From: [Planning](#)
To: [A30 Chiverton to Carland Cross](#)
Subject: RE: A30 Chiverton to Carland Cross Improvement Scheme - deadline 7 [S-S.FID646289]
Date: 15 July 2019 16:09:30
Attachments: [image001.png](#)

Sam Parker's highways consultants have considered HE's response (8.25 – published 08 July 2019) to their technical note provided on 20 June 2019.

ANNEX A - MCC Flow Diagrams by Peak Period

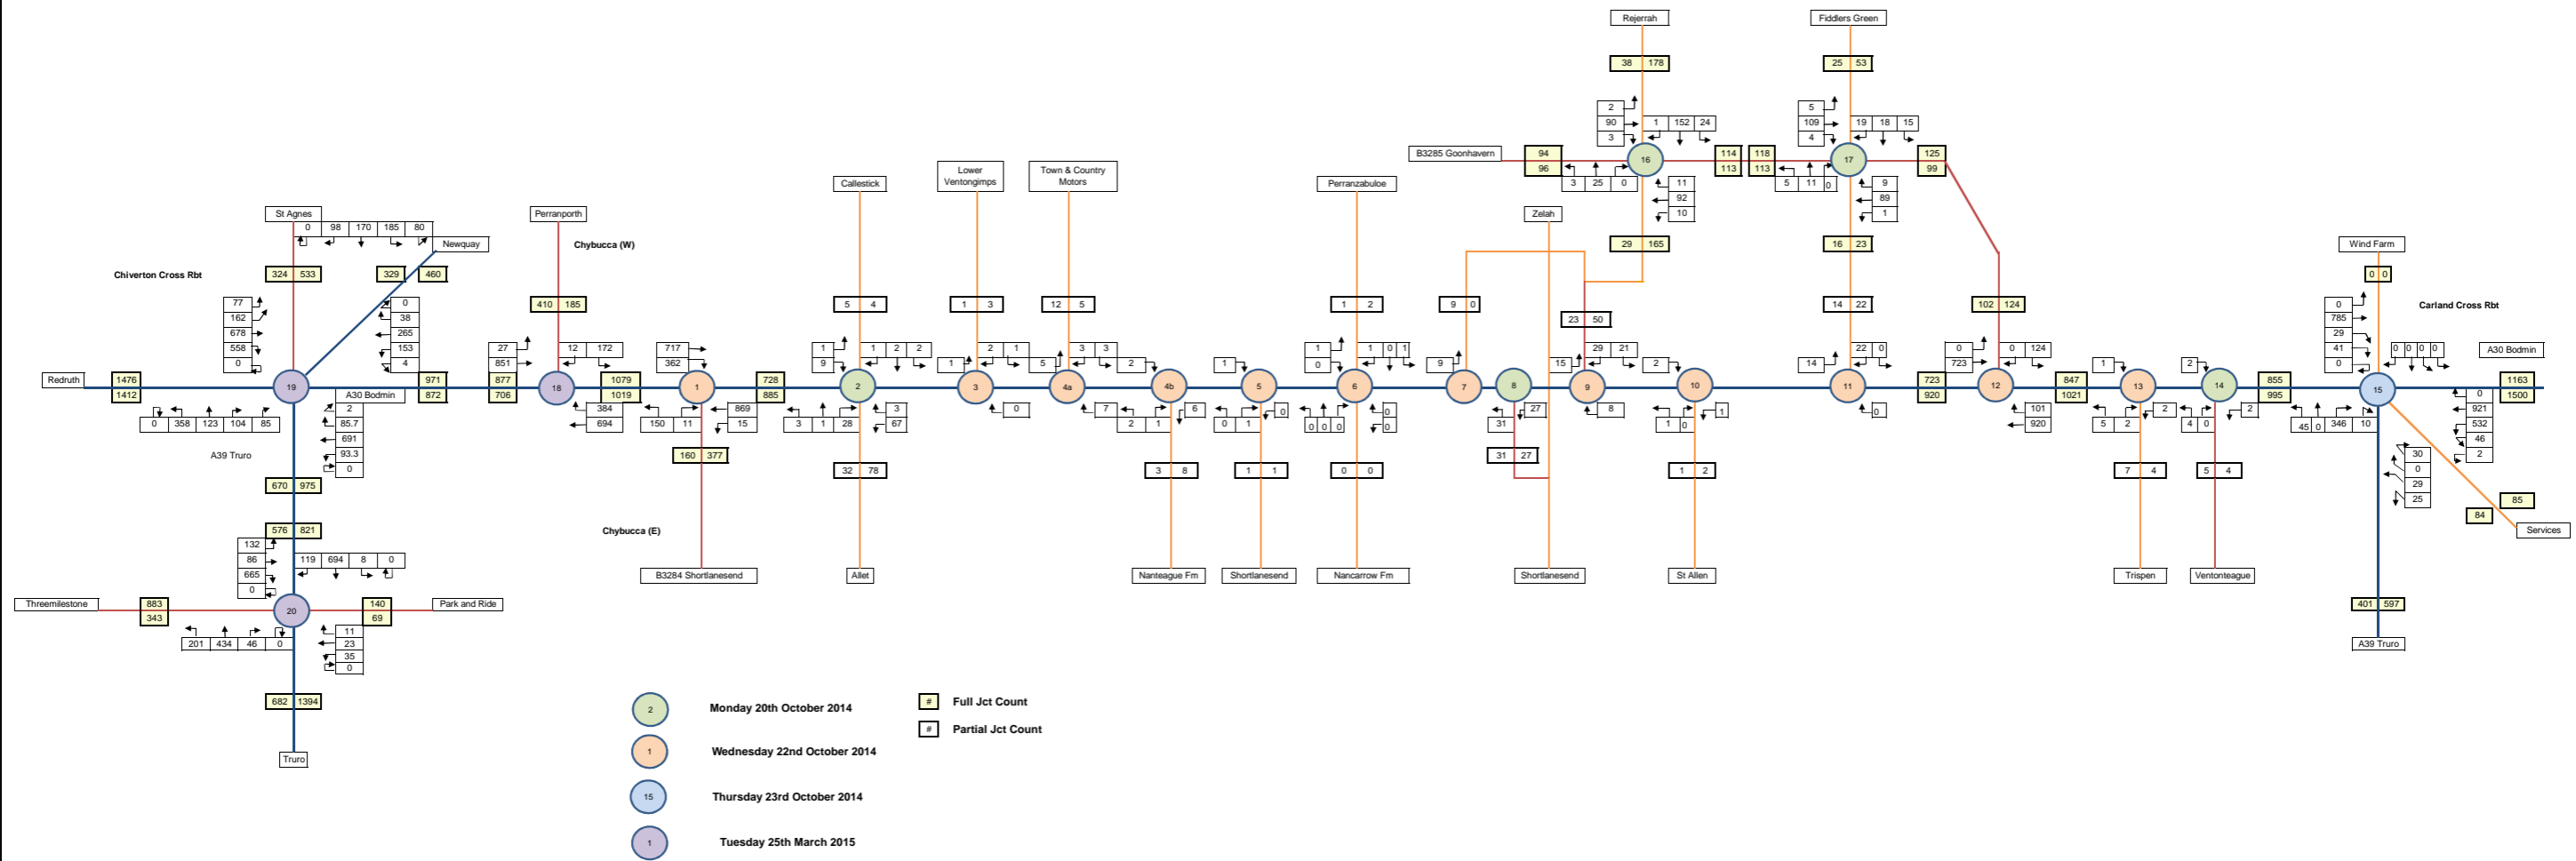
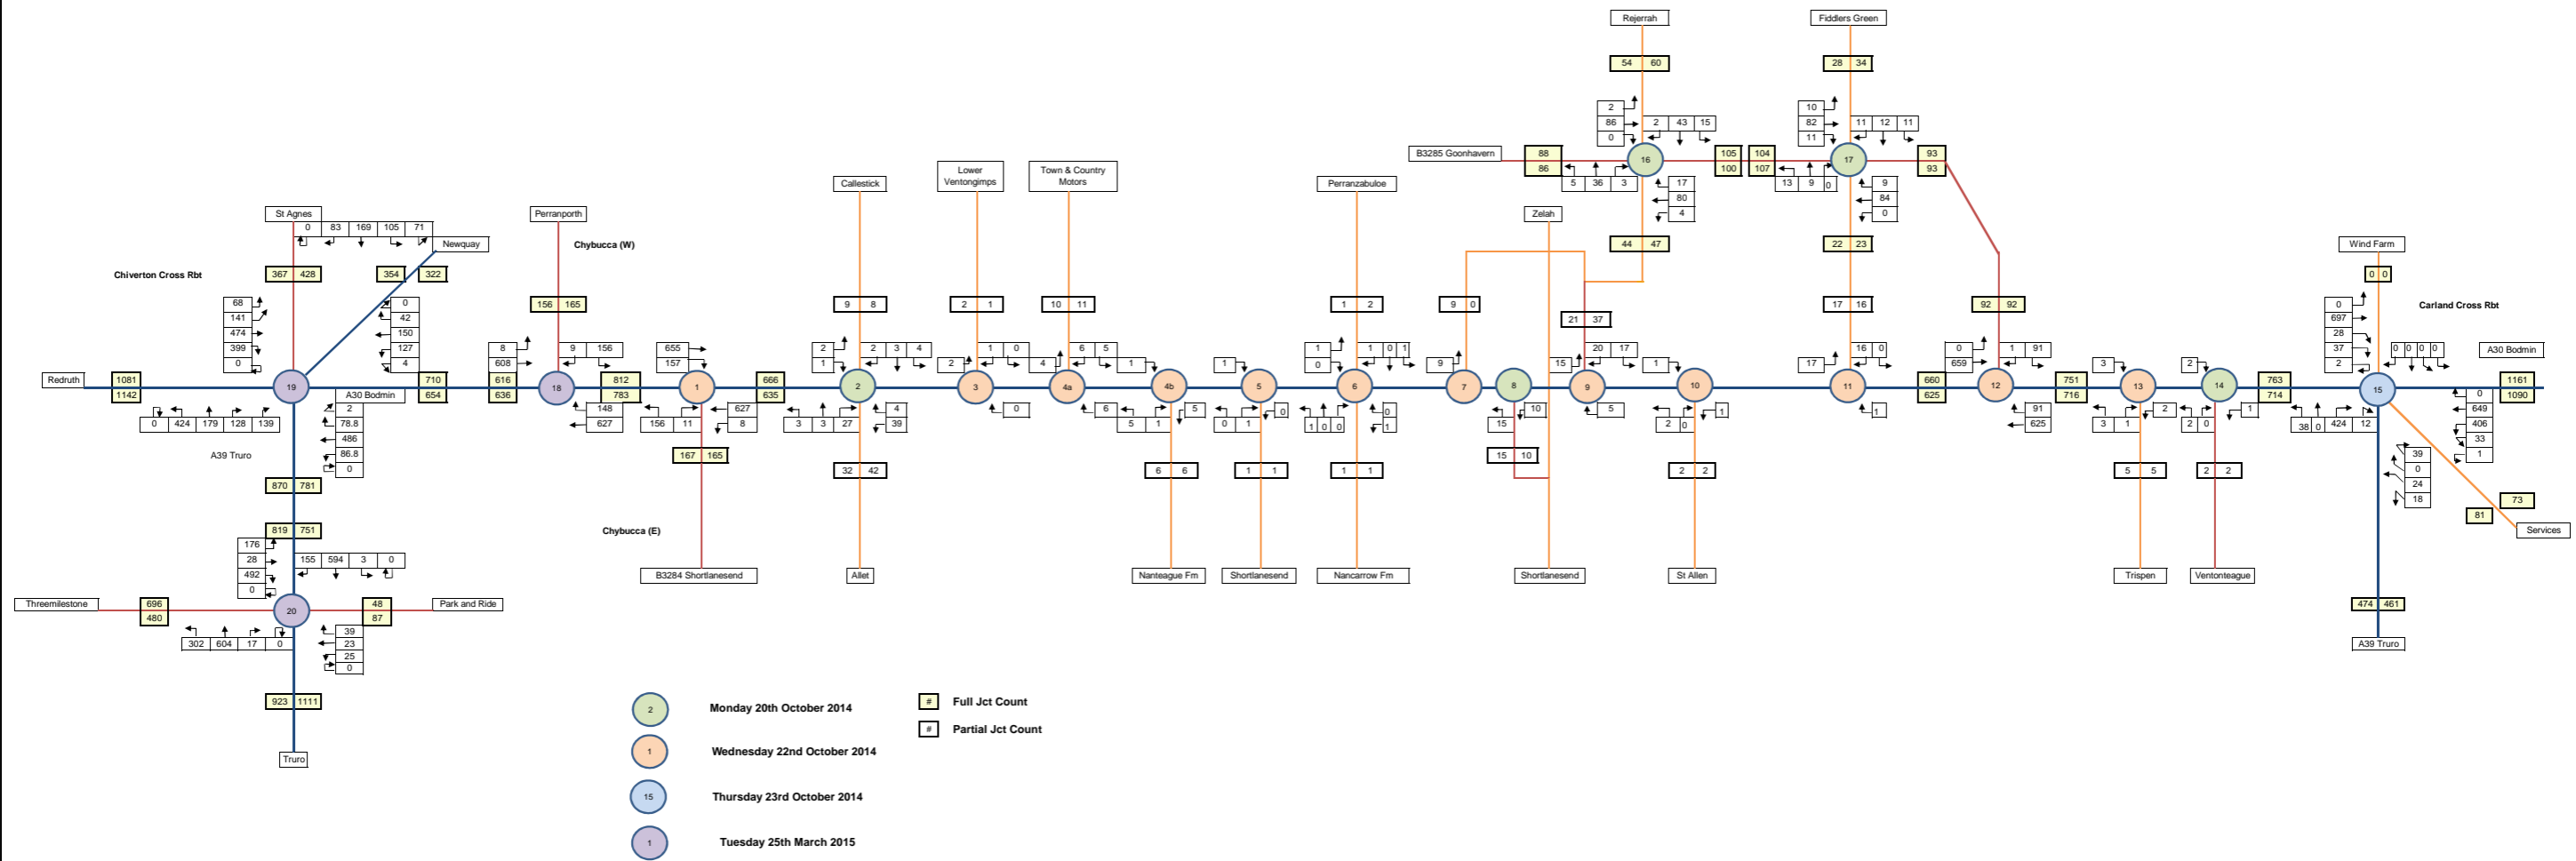
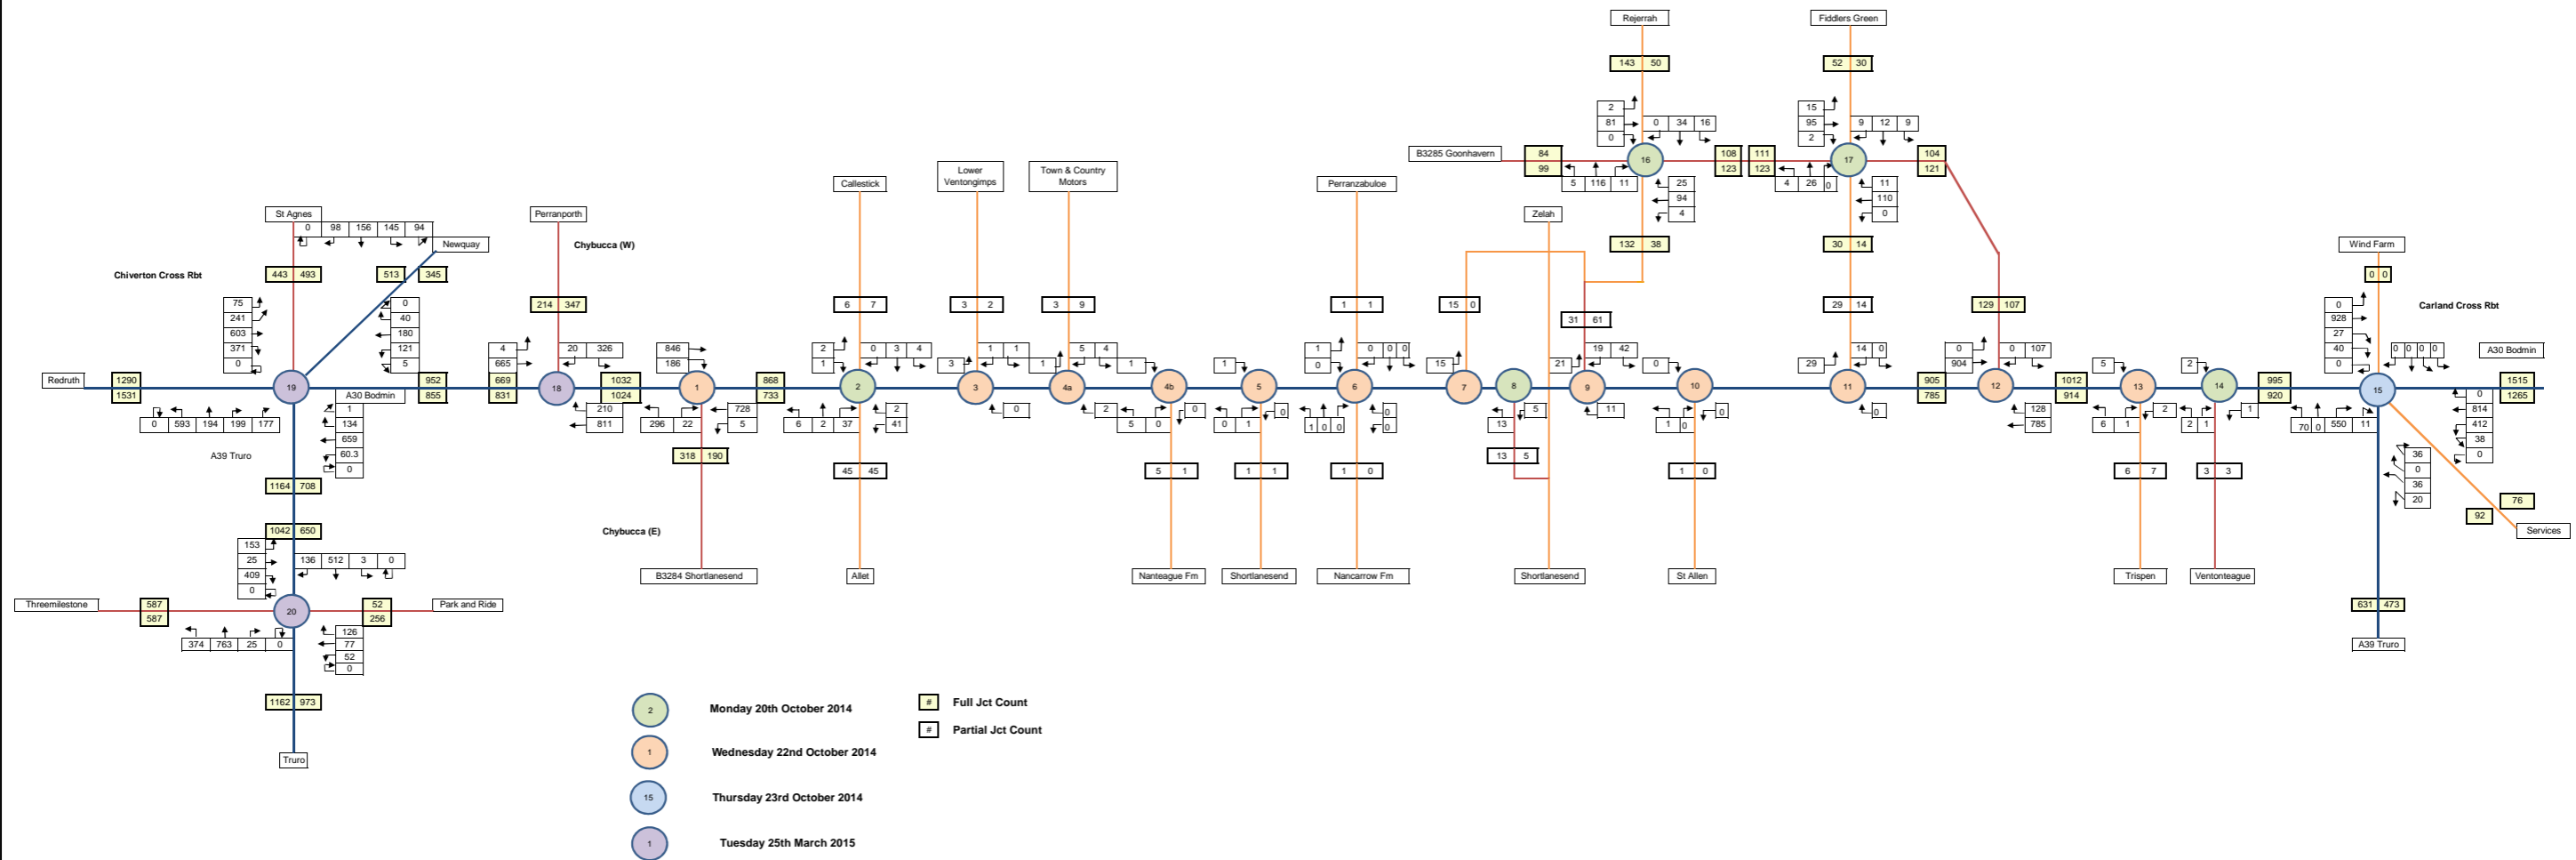
It appears that HE have simply "corrected an error" on the previous traffic flow diagrams provided to us, so the (updated) 'traffic collection report' diagrams match what is in the strategic model.

- 2.3.15-2.3.22 it is disappointing to have undertaken considerable analysis (in good faith) on work containing errors, the "corrected" diagrams are significantly different to the diagrams provided to us. It raises the question of what other errors have not yet been detected. Please provide all raw count data for the A30 / Chybucca Junction, with the contact information for the independent traffic count company or individuals who collected the data. Alternatively, please undertake new traffic counts of the A30 / Chybucca Junction, as a single junction (i.e. four arm staggered cross roads) to determine accurate across A30 / joining or leaving A30 data.

- 2.3.23-2.3.24 re low flows, taking the "corrected" junction count diagrams at face value, there are low flows (by HE's definition of sub approximately 100 veh/hr) at the west facing slips of the Carland Cross junction, and yet these are justified. The question is not whether there is more west facing traffic than east facing

2.3.25-2.3.28 the same comments apply to the PM peak (and, presumably, the Interpeak) period.
